Our Ref: K/6/20/HH

First floor rear extension, conversion of roofspace to habitable use. Part two storey part single storey front extension and demolition of existing conservatory and adjustments to flat roof dormer to north elevation on existing dormer to incorporate pitched roof.

Flint Barn Peak Lane Kingston

Client	
Mr K P & Mrs V L Eaton	
Project	
PROPOSED EXTENSION TO FLINT BARN, PEAK LANE, KINGSTON GORSE, WEST SUSSEX, BN16 1RN	
Title	
PROPOSED SECOND FLOOR PLAN	
Drawing Status	
PLANNING APPROVAL	
Drawn	Checked
KPE	
Scale	
1:50 @ A3	
Date	
31 Jan 2020	
Job No	Drawing Number
20/01	2020/Jan/Plan, 003

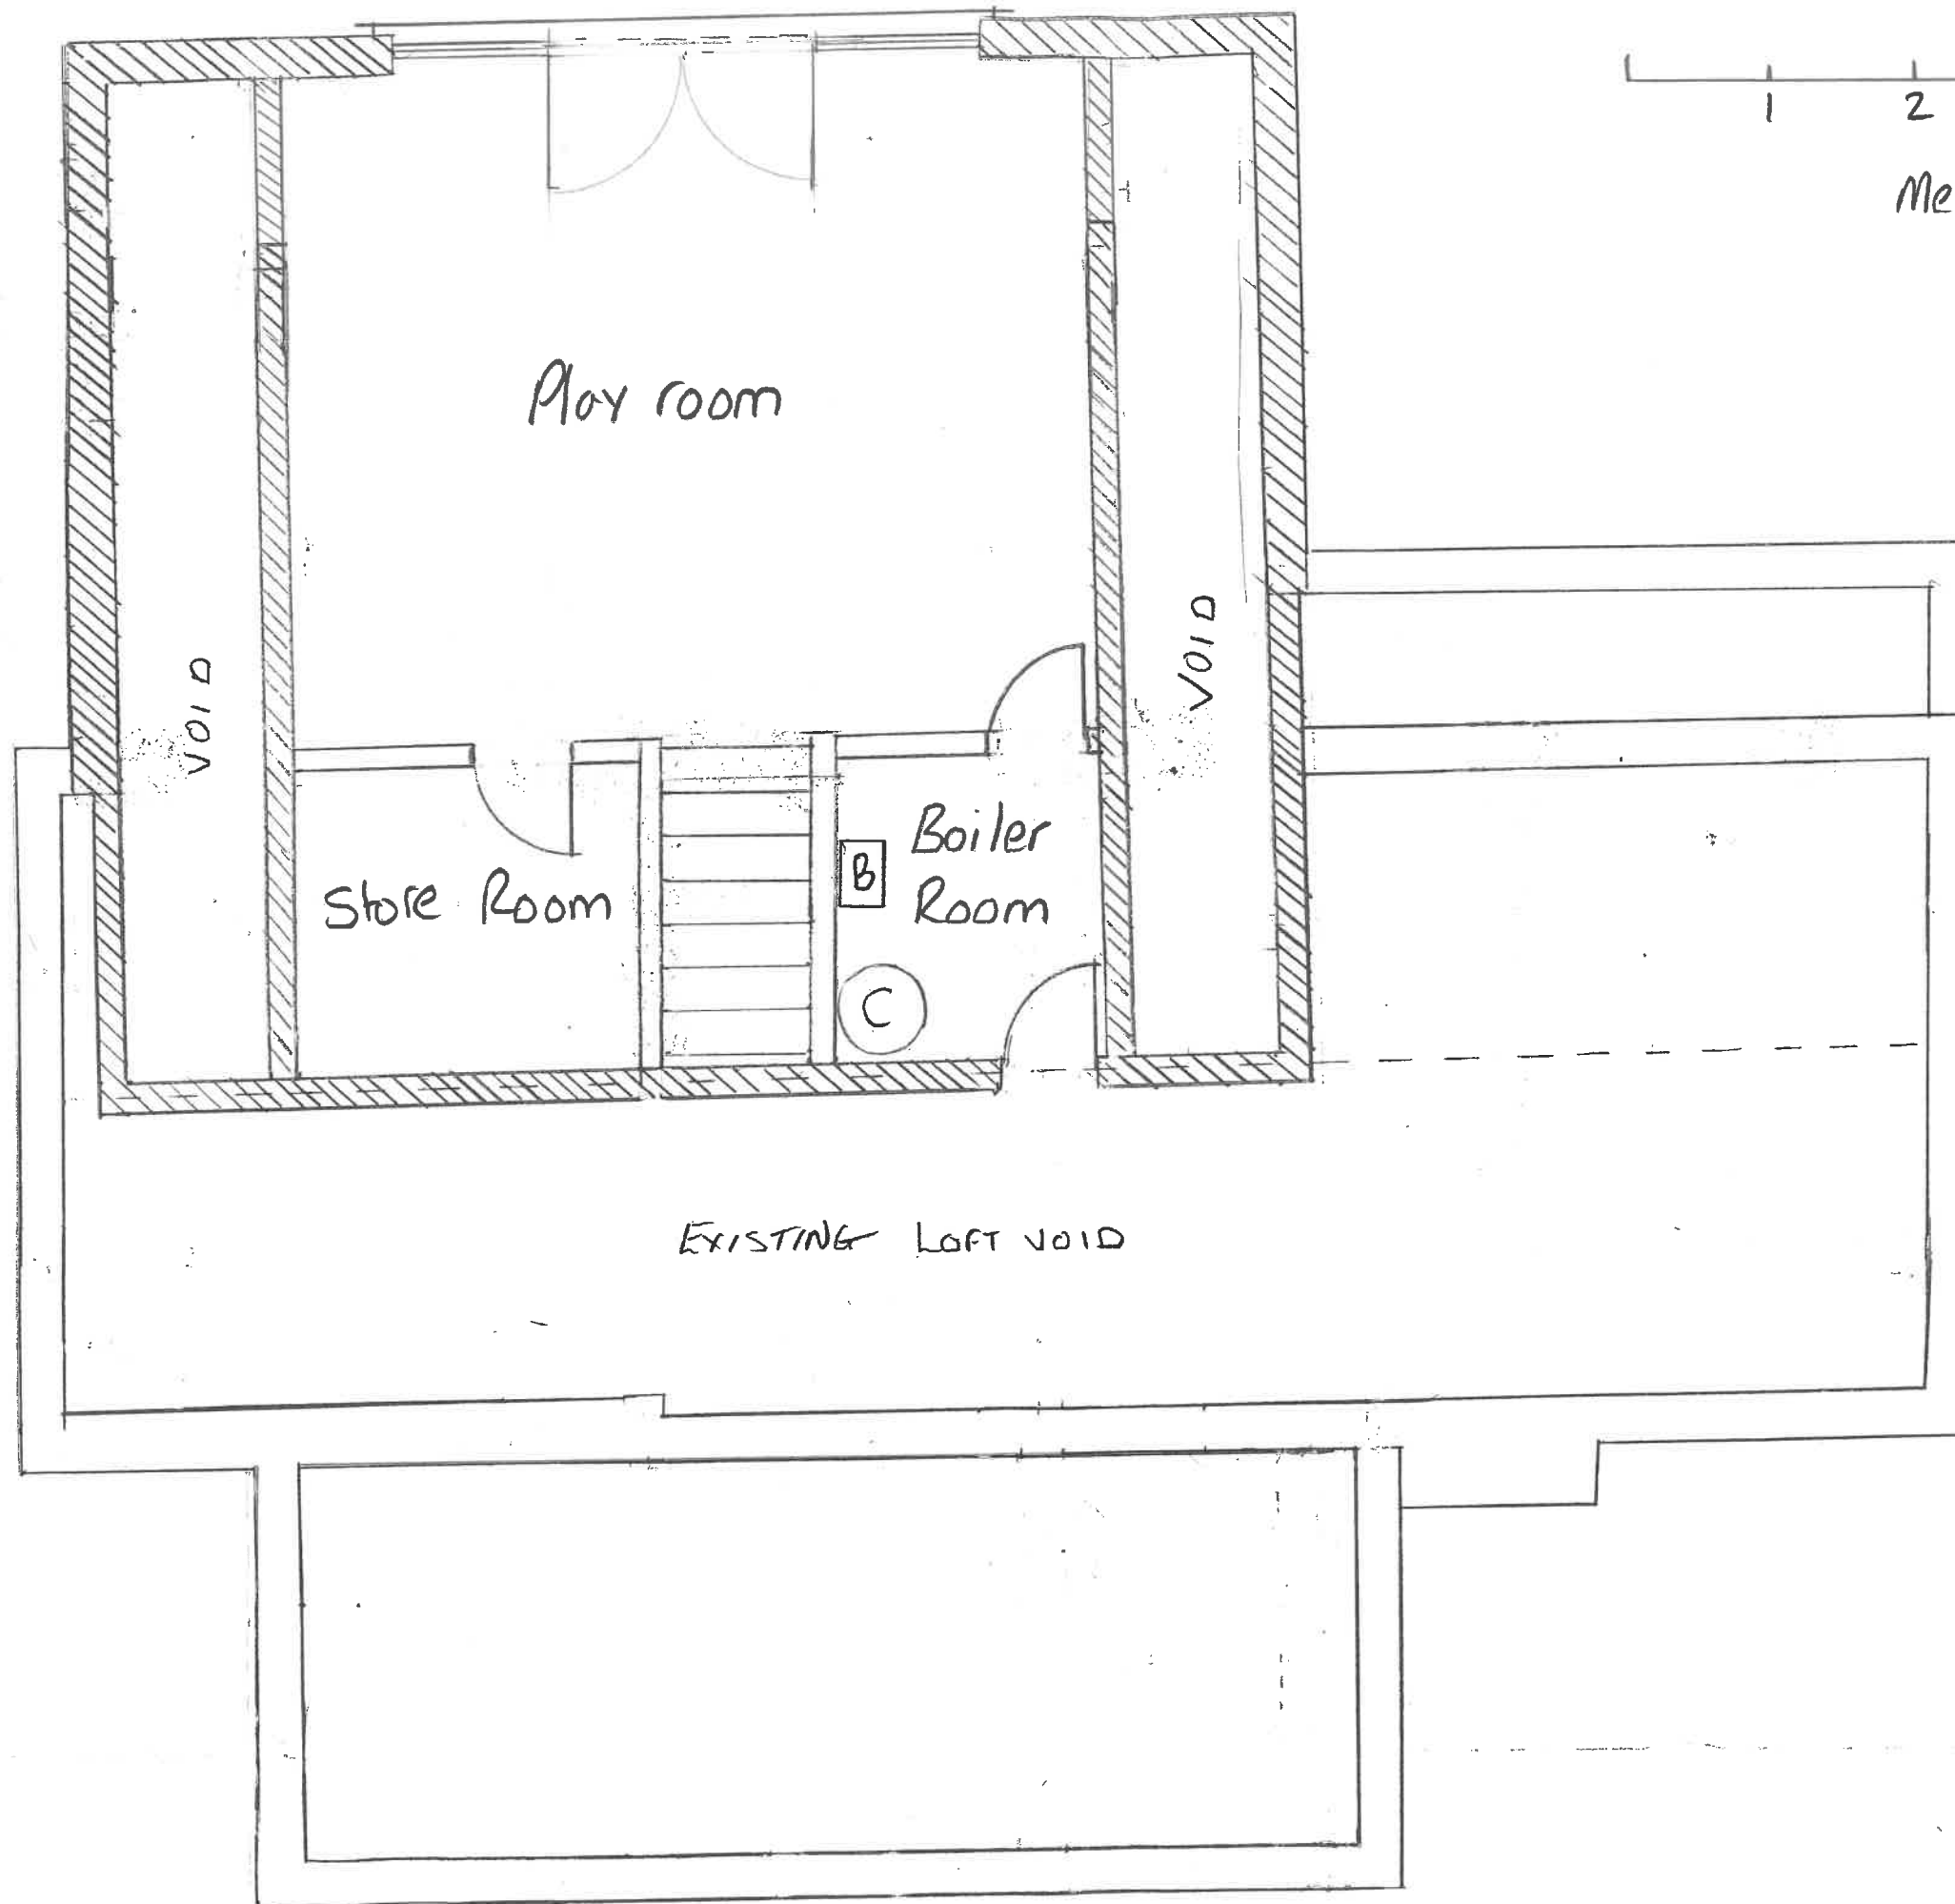
plans lacks detail.third floor ridge appears higher than existing roof line, intrusive to neighbouring properties,No mention of using any sustainable materials.
